WEST SUSSEX COUNTY COUNCIL CONSULTATION

TO:	Arun District Council FAO: Simon Davis
FROM:	WSCC - Highways Authority
DATE:	2 July 2019
LOCATION:	10 Barrack Lane, Bognor Regis, PO21 4BZ
SUBJECT:	AW/177/19/DOC Approval of details reserved by condition imposed under AW/259/18/PL relating to conditons 4-pre-commencement meeting, 6-hard surface details, 7-colour schedule of materials & finishes, 8-details of new screen walls and/or fences, 10-covered & secure cycle parking, 11-dustbin enclosure/collection point details, 12-electrical vehicle charging point, 13-decentralised, renewable or low carbon energy systems & 14-visibility splays.
DATE OF SITE VISIT:	N/A
RECOMMENDATION:	Advice
S106 CONTRIBUTION TOTAL:	£N/A

This proposal seeks to discharge conditions 4, 6, 7, 8, 10, 11, 12, 13 and 14 secure under approved AW/259/18/PL (1 No. dwelling).

Block Plan 1 : 500

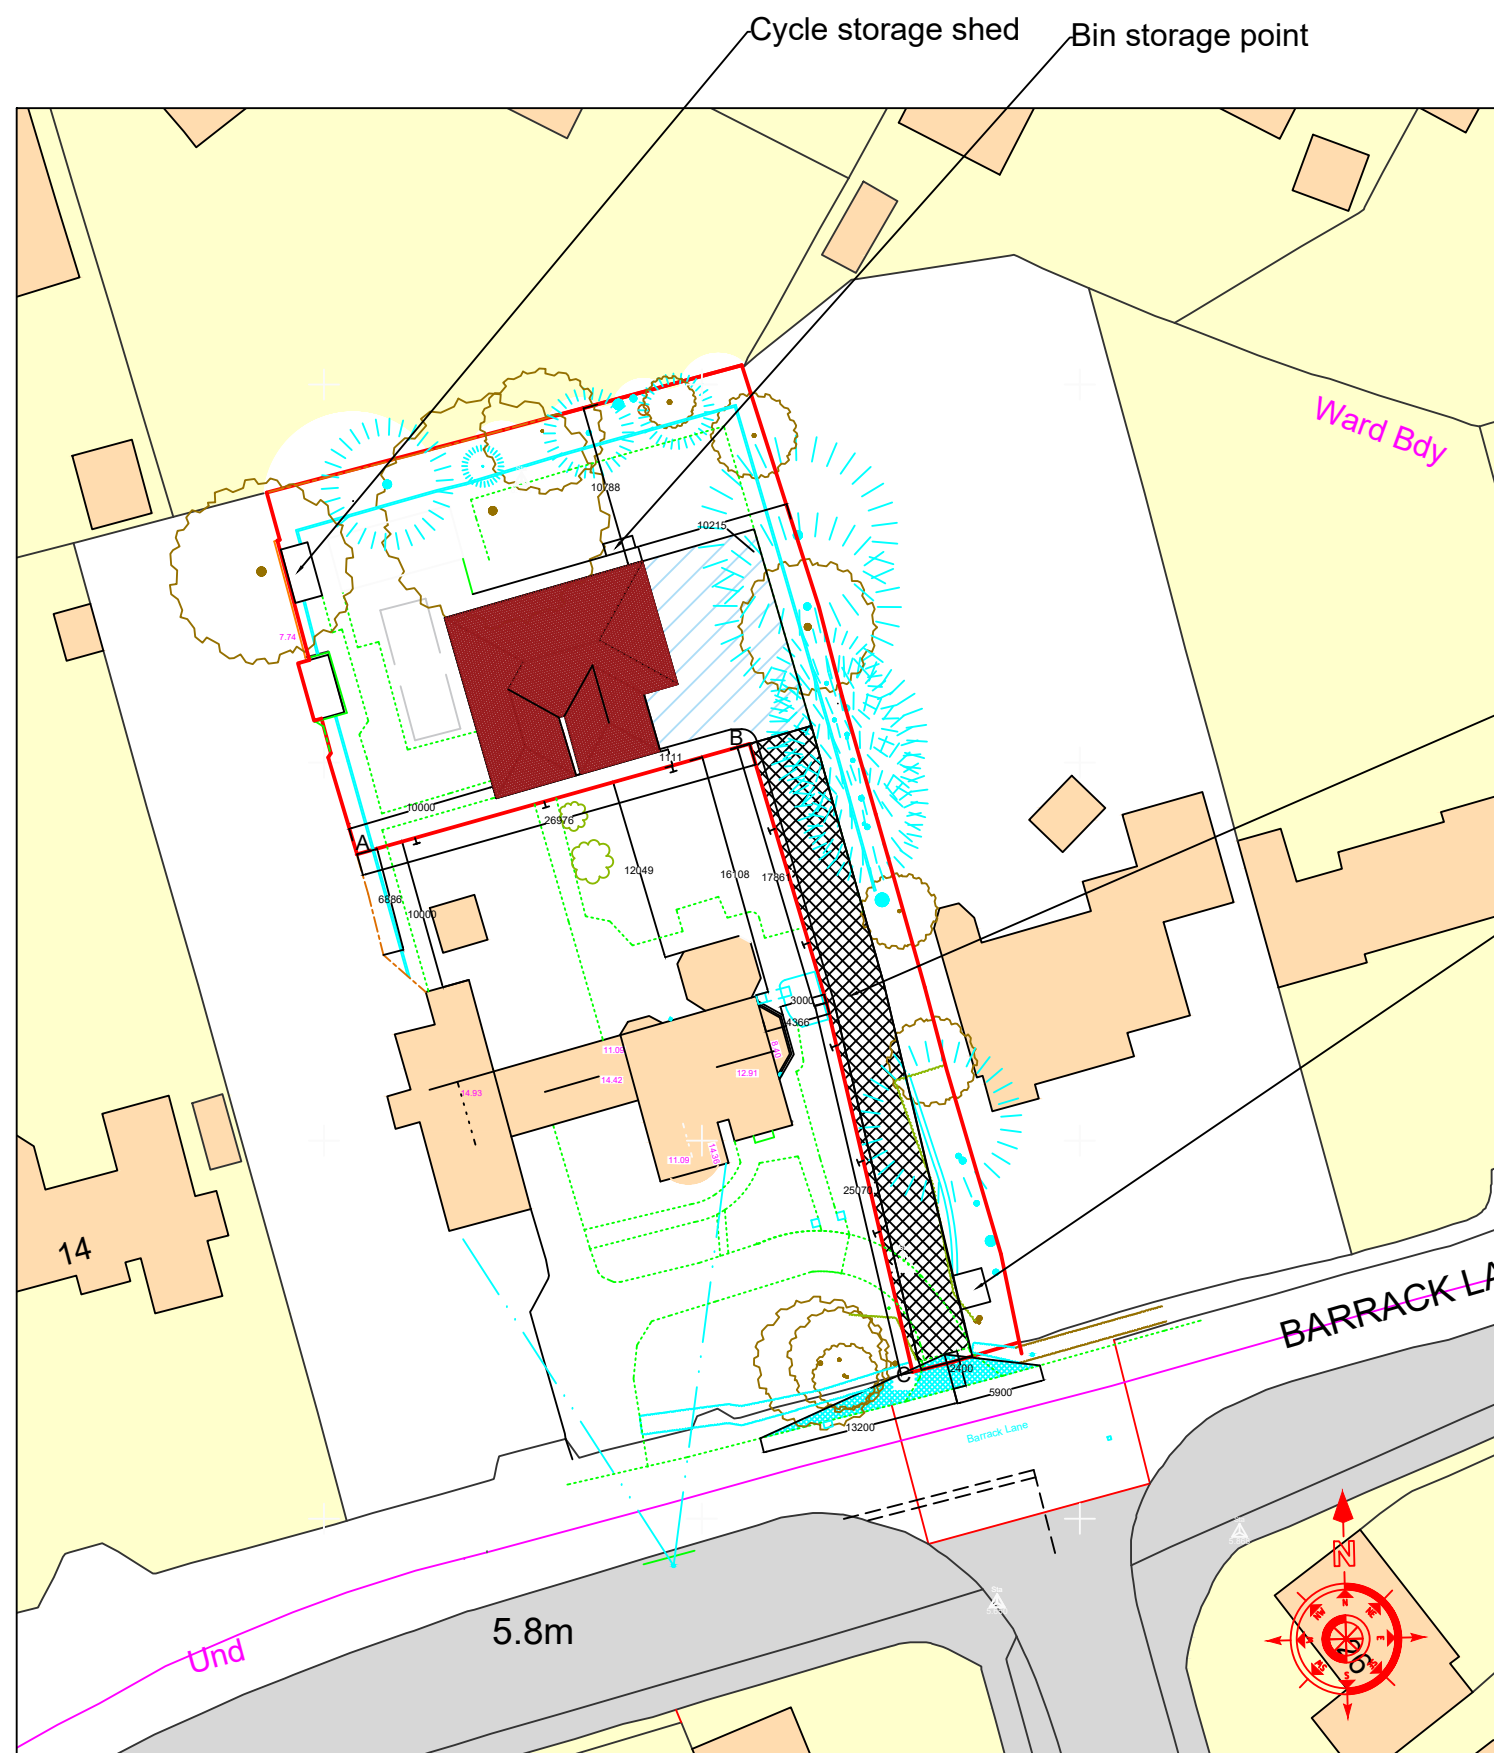
Maximum achievable visibility splays of 13.2m to the west and 5.9m to the east set back 2.4m from the edge of the highway at the existing point of access were demonstrated.

In Conclusion, the Local Highway Authority is satisfied that Conditions 10 & 14 can be discharged.

Tiger Overlap Apex Shed

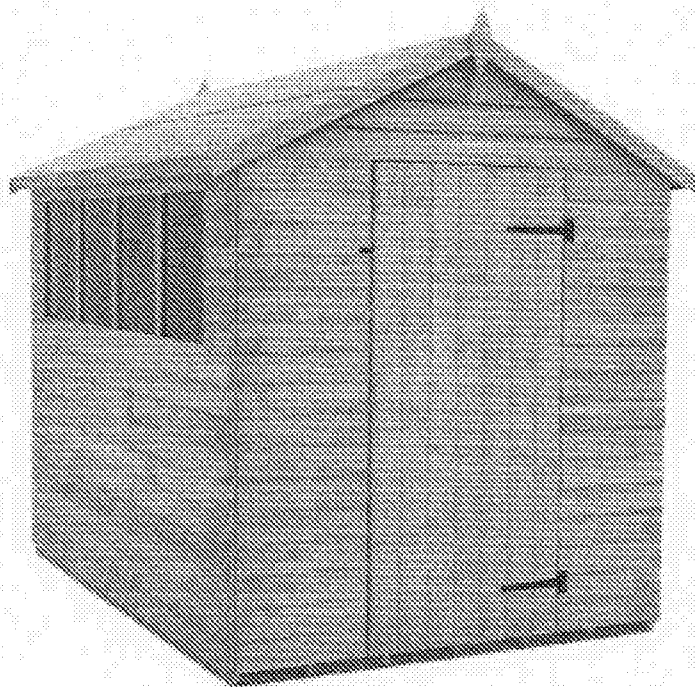
Condition 10 – Covered & secure cycle parking
A cycle storage shed with dimensions of approximately 1.8m x 3.7m is to be provided to the northwest of the property. This will allow for the secure and covered storage of a number of cycles.
